Planning Application Ref: 3/2016/0269

Description of Development: Proposed agricultural building

Site Address: New House Farm, Grunsagill Road, Bolton by Bowland, BD23 4SQ

title
Plan, Elevations & Section

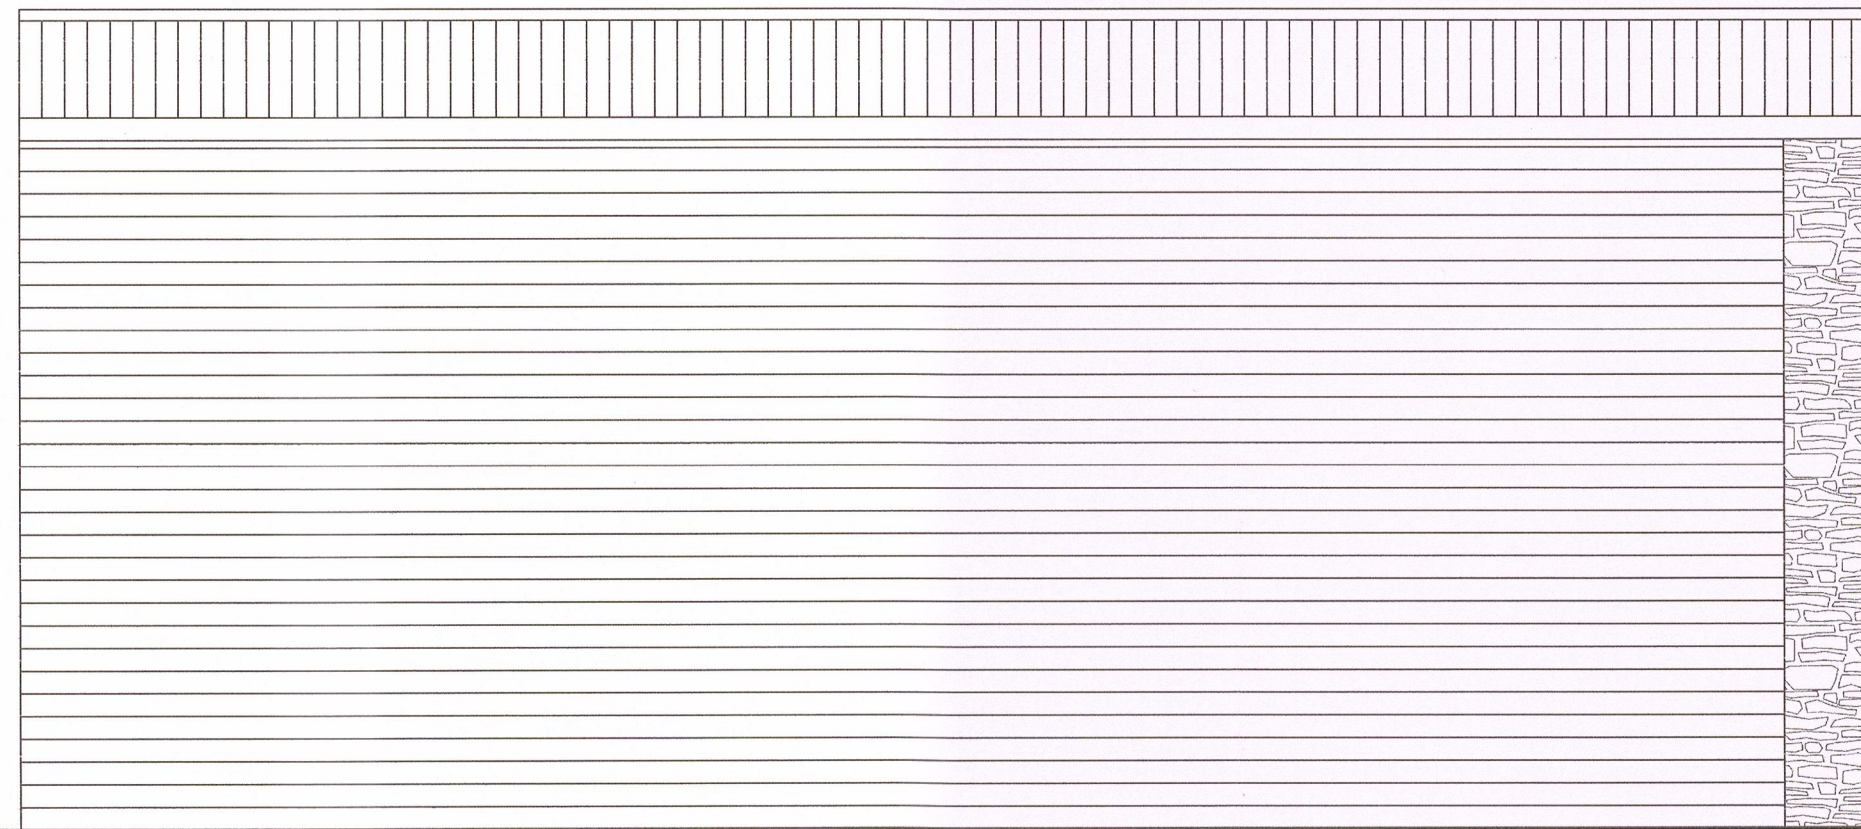
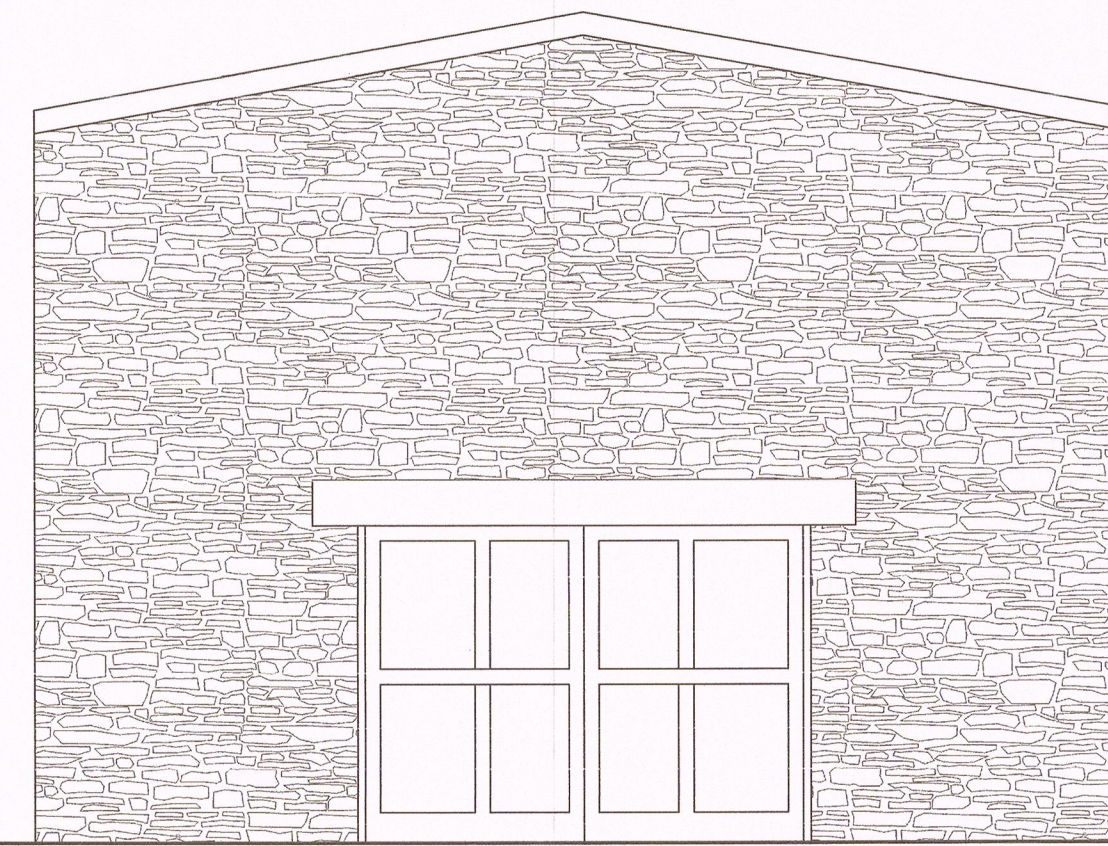
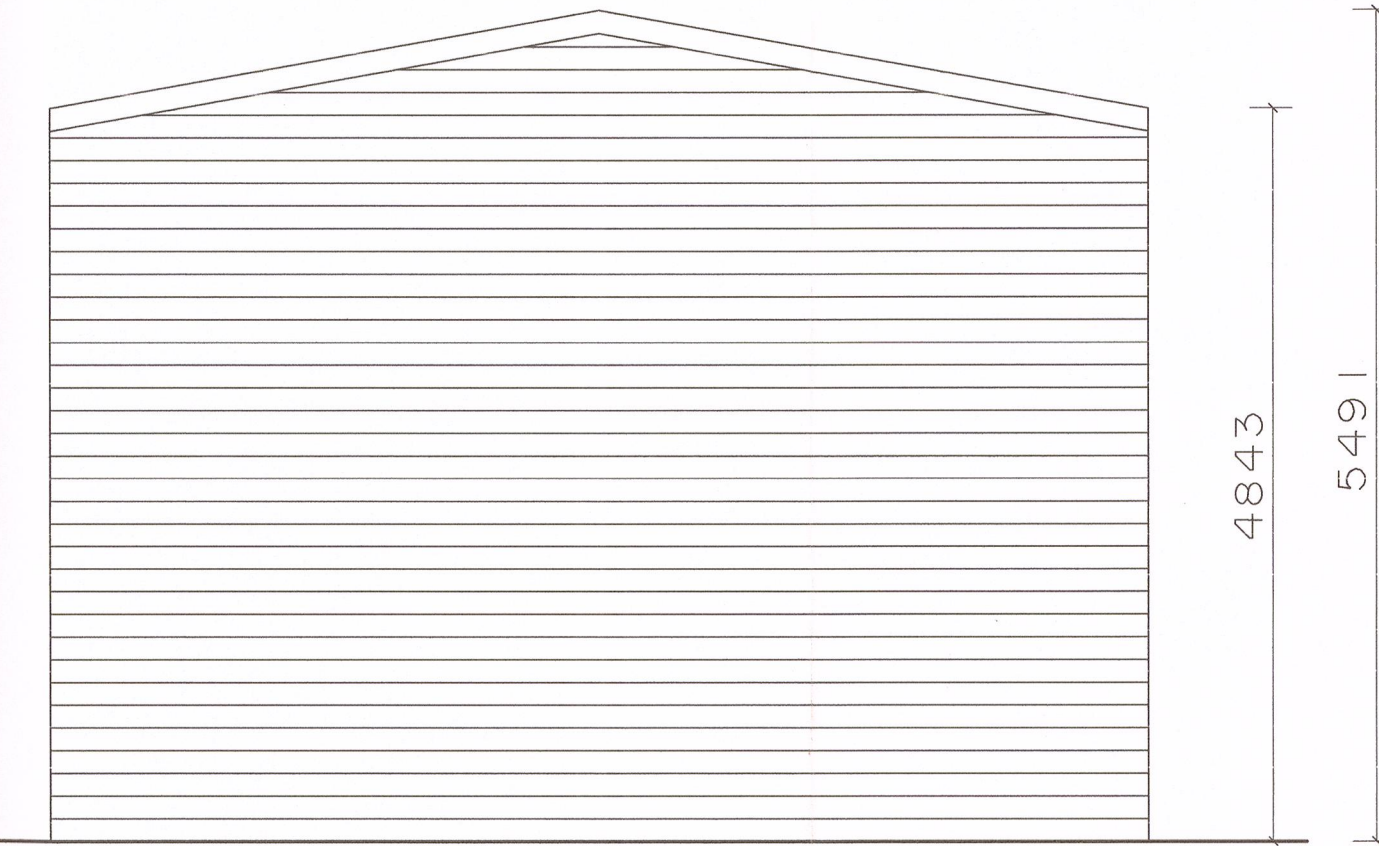
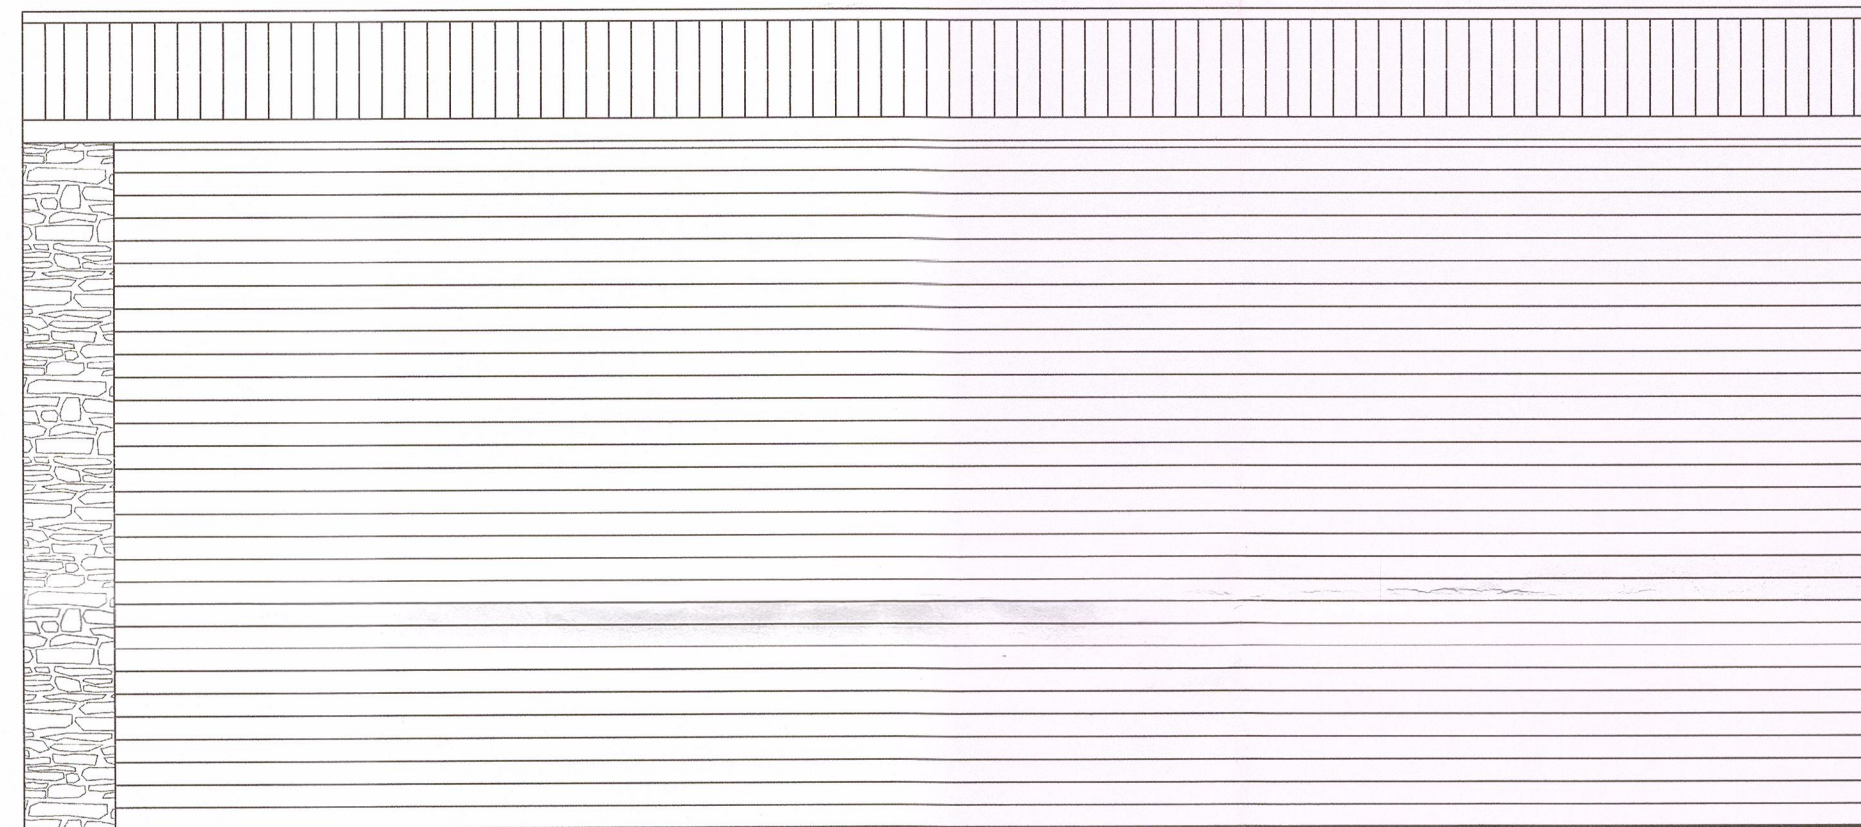
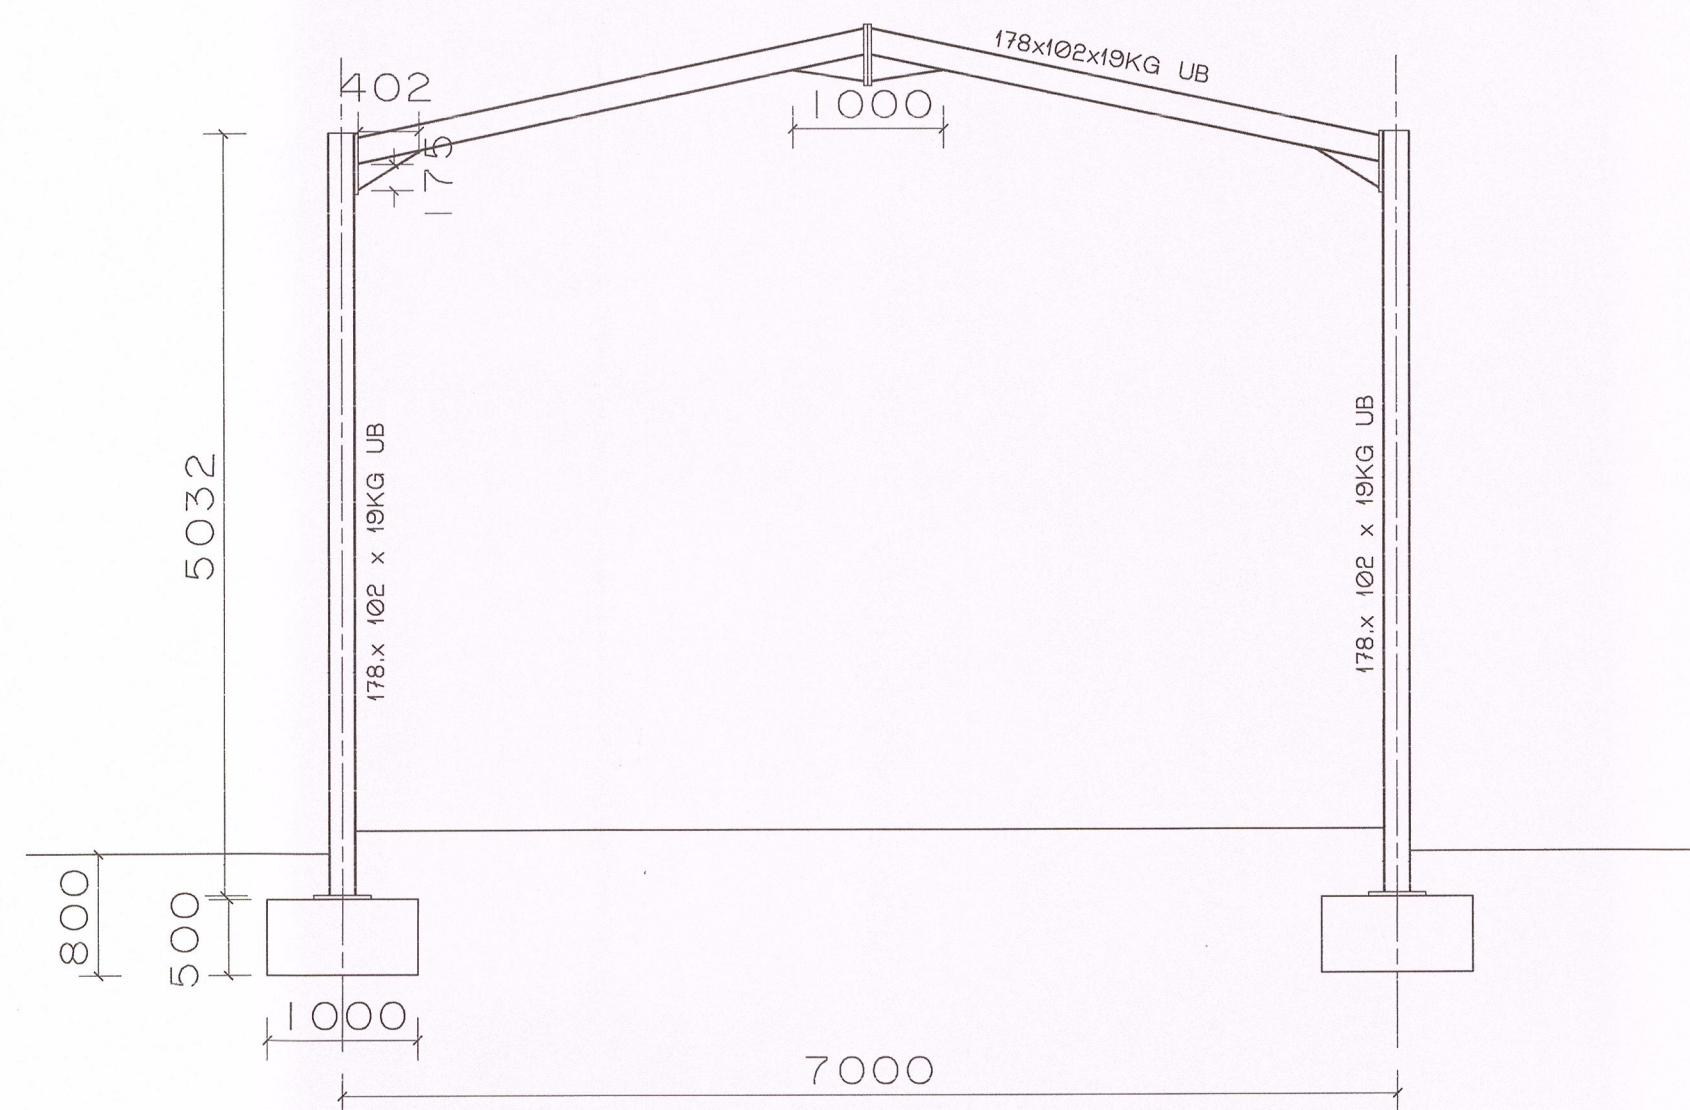
Agricultural buildings should be built to British Standards. If a building is to house livestock, which is suggested in the Planning Statement, then I would also question if the building is appropriate in its design. The British Standards for livestock buildings require construction to exclude harsh weather and draughts but provide maximum ventilation. I am concerned that the building, as designed, would not meet this requirement because of the blockwork walling, clad with timber externally and the stoning of the front of the building.

The site is located within the open countryside and an Area of Outstanding Natural Beauty (AONB), therefore consideration should be given to policy guidance that covers development in the countryside and AONB. Policies contained within the Core Strategy advise that development should protect and enhance the character of the landscape and acknowledge the special qualities of the area by virtue of their size, design, use of materials, landscaping and siting (Policies DMG1, DMG2 and DME2). Notwithstanding the concerns raised above regarding the 'need' for such a development, there are also concerns that the proposed building does not appear to be of an appropriate agricultural appearance or scale for its intended use. The building has a very shallow roof pitch and raised eaves, resulting in very large expanses of wall (using single materials and colours) which increases the massing and appearance of the walls. The height of the one opening on the front elevation also appears to be restricted for the use of storing agricultural machinery and does not sufficiently break up the massing on this elevation.

Given the location of the building within the AONB, the design of this building does not enhance the character of the wider landscape or respect the local vernacular. The principle of the development does not appear to be in line planning policies or guidance contained within the Agricultural Buildings and Roads, Supplementary Planning Guidance.

- There is a lack of evidence of agricultural activity at the farm (from the Case Officers site visit) and therefore a lack of evidence to support the need for a building.
- No evidence has been provided in the accompanying Planning Statement about how the building will be utilised by the applicant as part of the management of a viable farm.
- There are concerns that the design of the building provides appropriate ventilation to house livestock.
- There are concerns that the design of the agricultural building is not appropriate in terms of its scale, height and massing for its location within the AONB.
